Address: 26, BROUGHAM ROAD, MARSDEN, HUDDERSFIELD, HD7 6BN

Application number: 2026/90232	
What is the application for?:	Redevelopment of mill complex of 11,584sqm for mixed use development, including
Address of the site or building:	New Mills, Brougham Road, Marsden, Huddersfield, HD7 6AZ
Postcode:

### User comments

BOUNDARY SECTION J

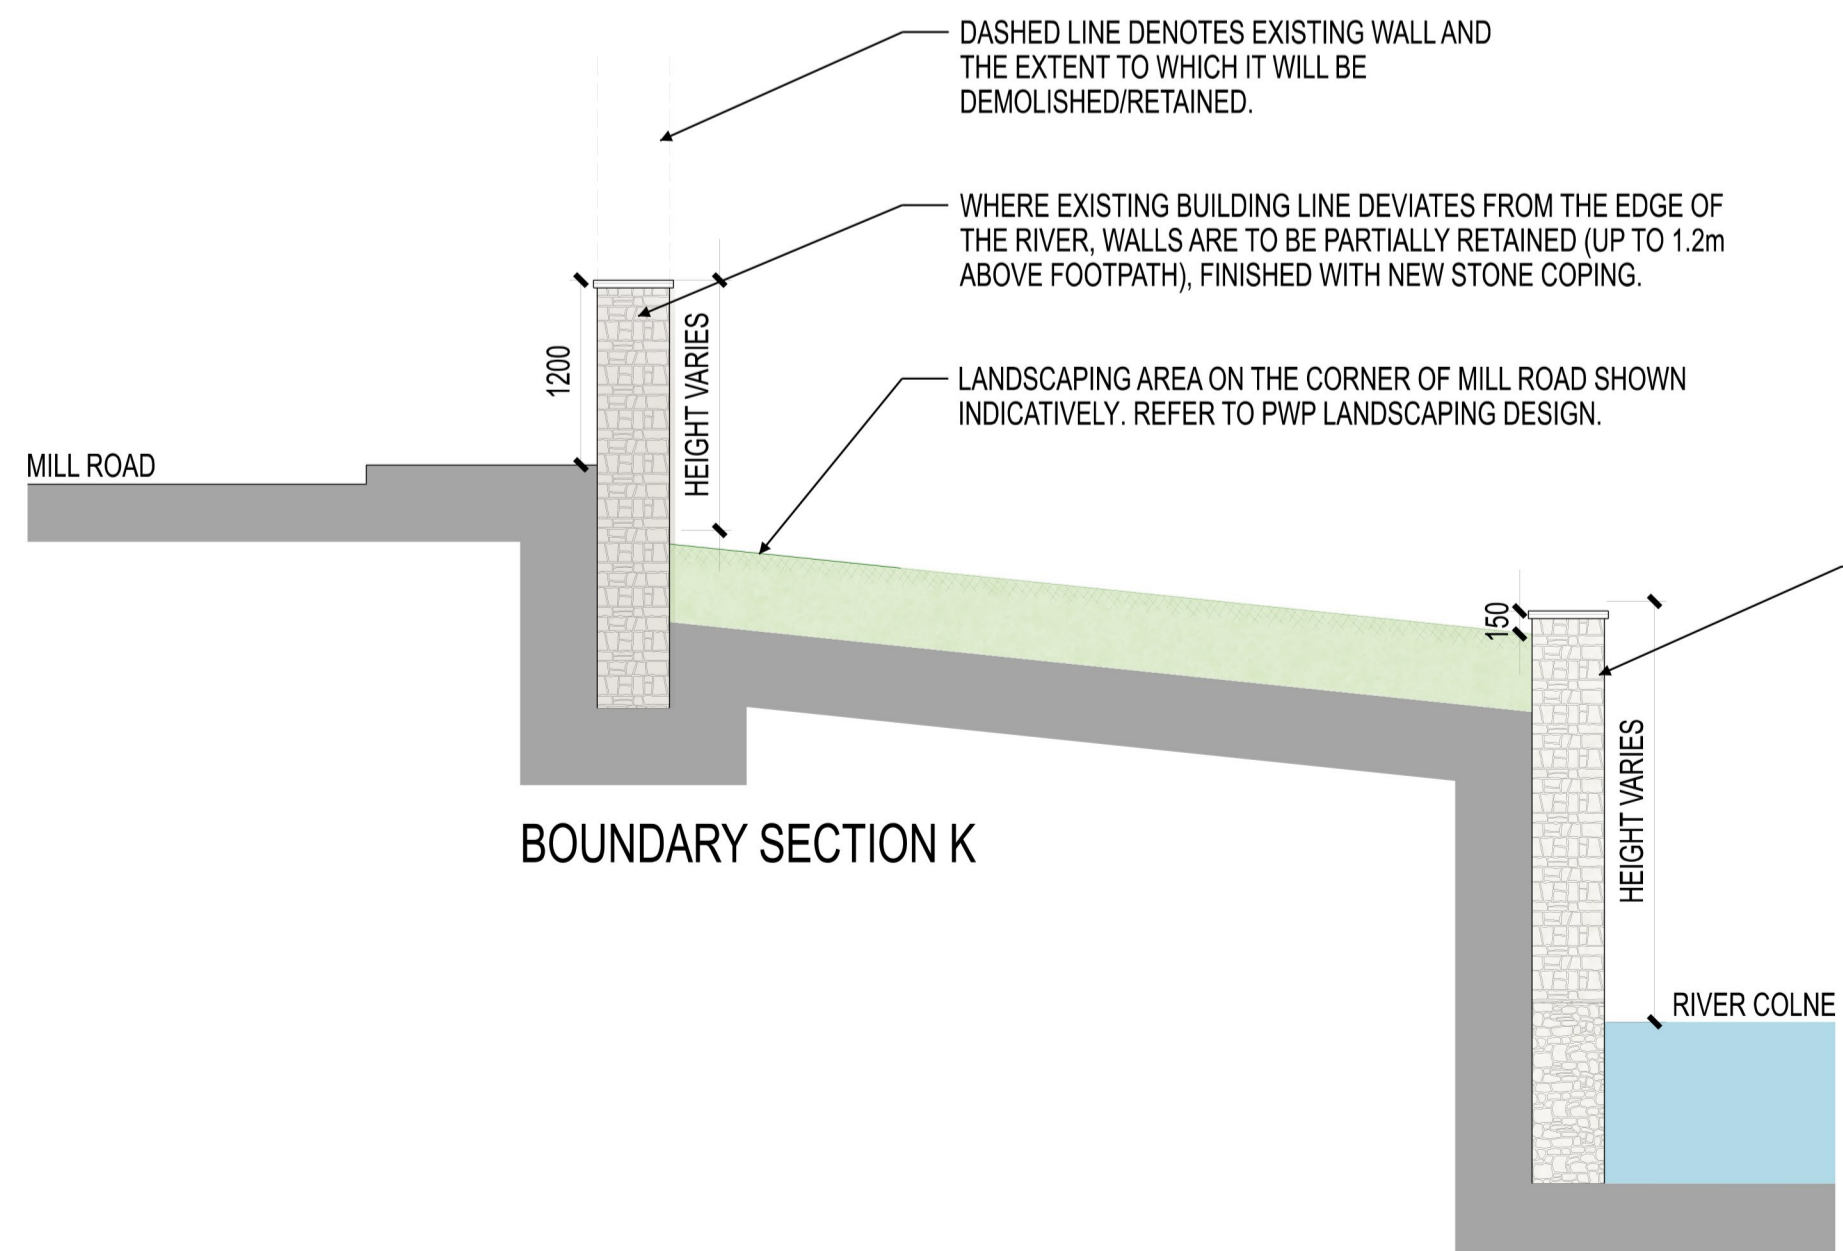
Type of comment: A general comment	
Do you wish your comments to be published on the website anonymously?	No
I have lived on Derby Terrace for 14 years, and have a mature garden which I have built up from scratch when I moved in. It is now very much dependent on the wall behind it, which is apparently going to remain. Can you guarantee that this wall will, in fact, remain, and that I will not lose my garden? Thank you
